Re: RESPONSE TO SUBMISSIONS

**MINOR MODIFICATION OF MAJOR PROJECT APPLICATION NO. 06_0025 (MODS 5 & 6) –
VINCENTIA DISTRICT TOWN CENTRE – “MOD 7”**

SITE PLAN-VINCENTIA DISTRICT TOWN CENTRE MOD 7 DESIGN RESPONSE

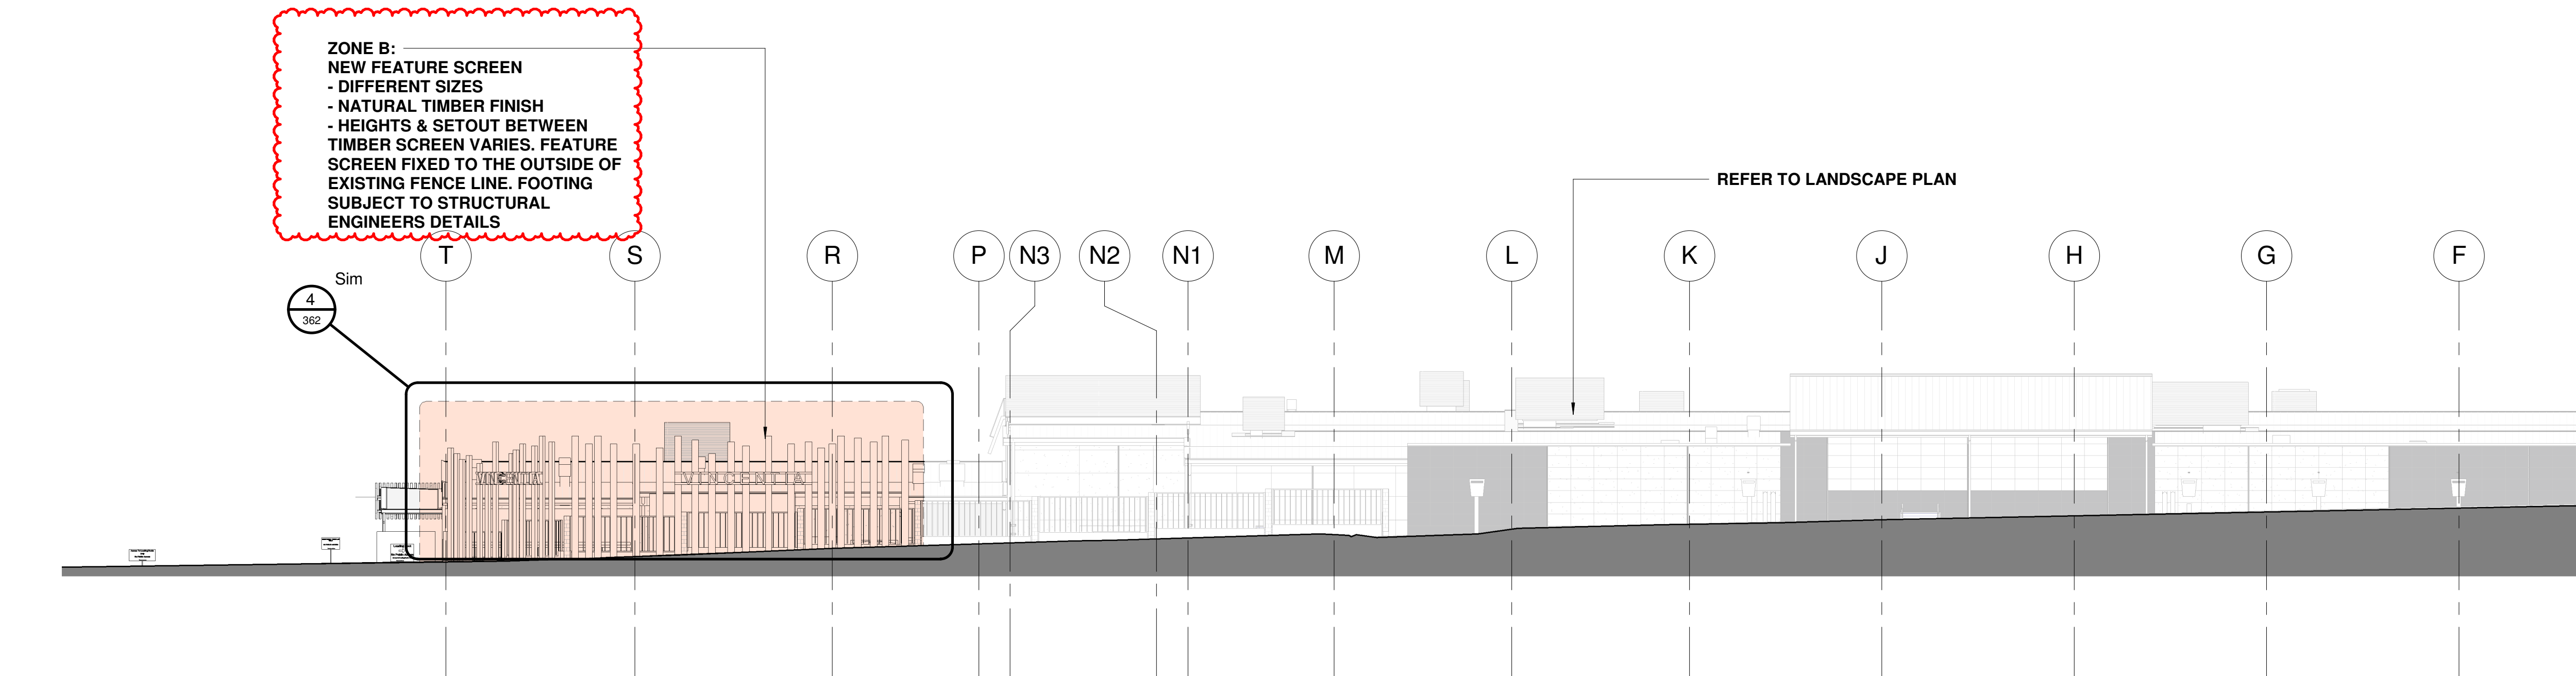
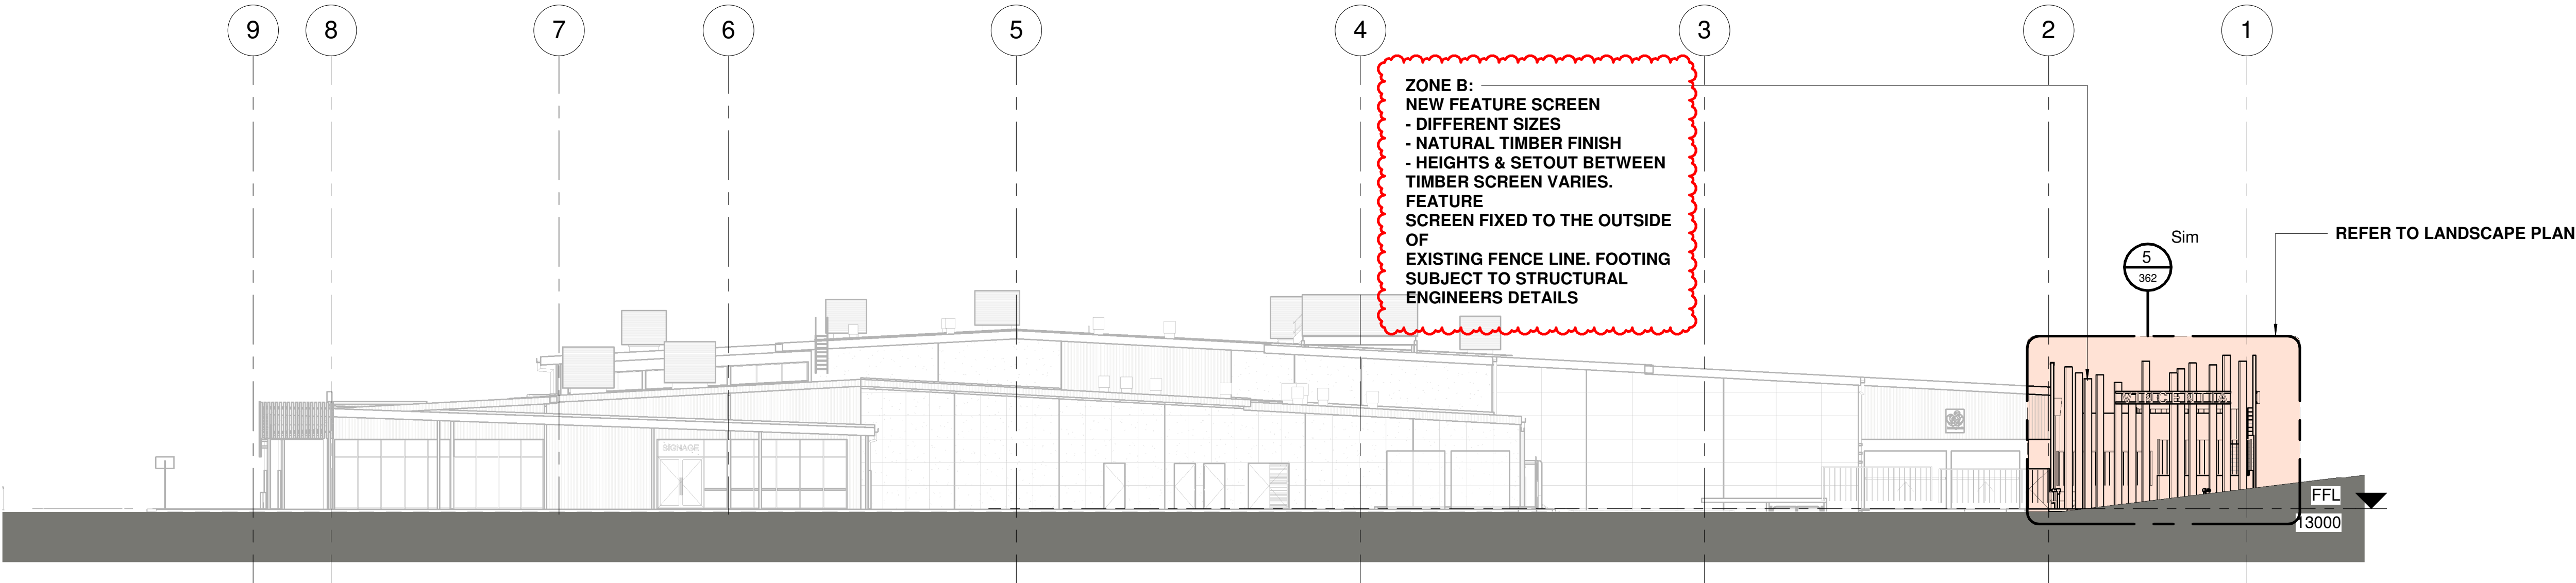
I apologise for the delay and thank the Department for giving Council the opportunity to provide comment on the proposal. Council has reviewed the submitted documents and supports the provision of the timber screen feature near the loading dock area which will screen the sprinkler tank and improve the aesthetics of this area. Council supports the provision of additional landscaping as indicated on the submitted plans.

1. Noise – the proposed timber screen does not address noise;
2. Landscaping – the proposed changes are inadequate;
3. Completion – queries when approved works will be completed; and
4. Compliance – queries what compliance action has been taken by the Department.

The proponent’s position is unchanged. The details in this Modification are for a timber screen as a visual feature.
